Our Ref: 1539-GM
20th November 2017

Re: Proposed development No 1 Beehive Lane, Ferring
Your ref: FG/33/17/PL

Proposed Elevations

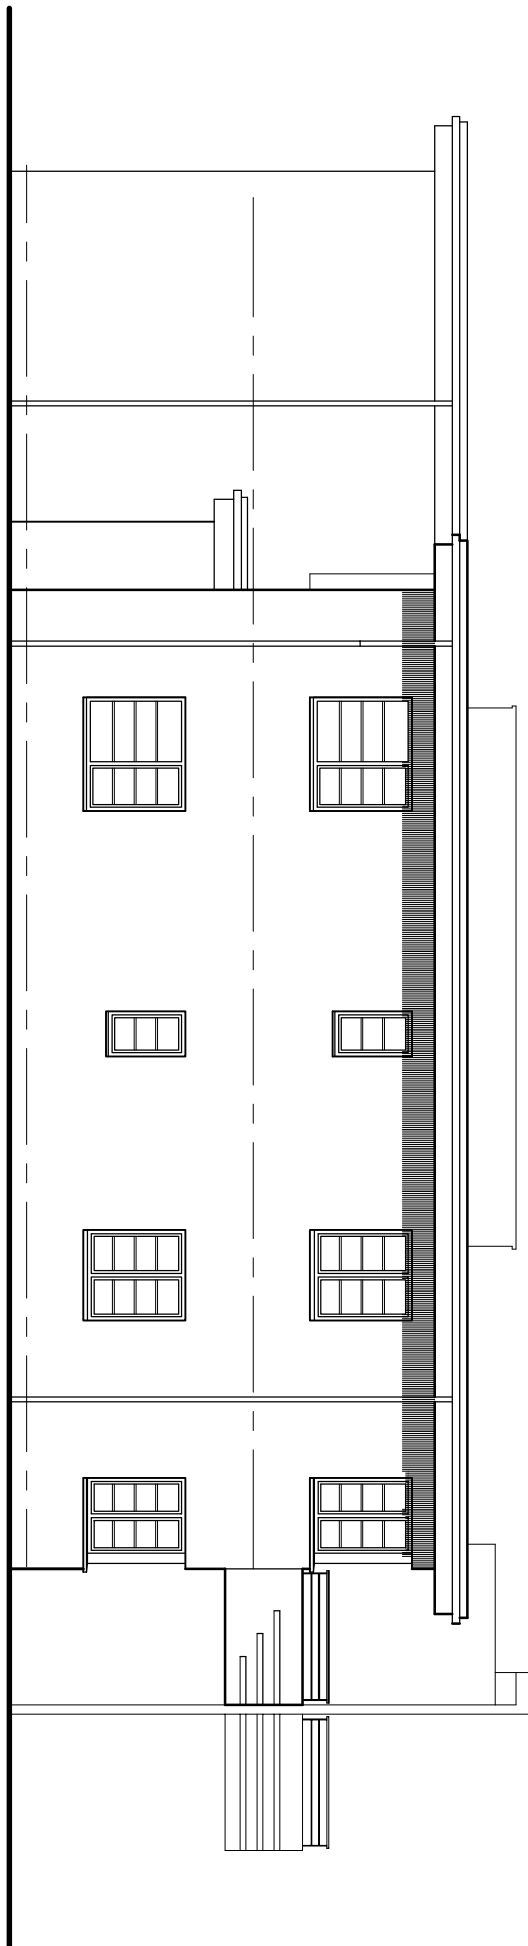
The amendments for which we seek approval include changes to the horizontal glazing bars to doors and windows and the omission of the fanlight over the main entrance door. These changes are clearly shown on the attached drawing 1539-2.18 rev H.
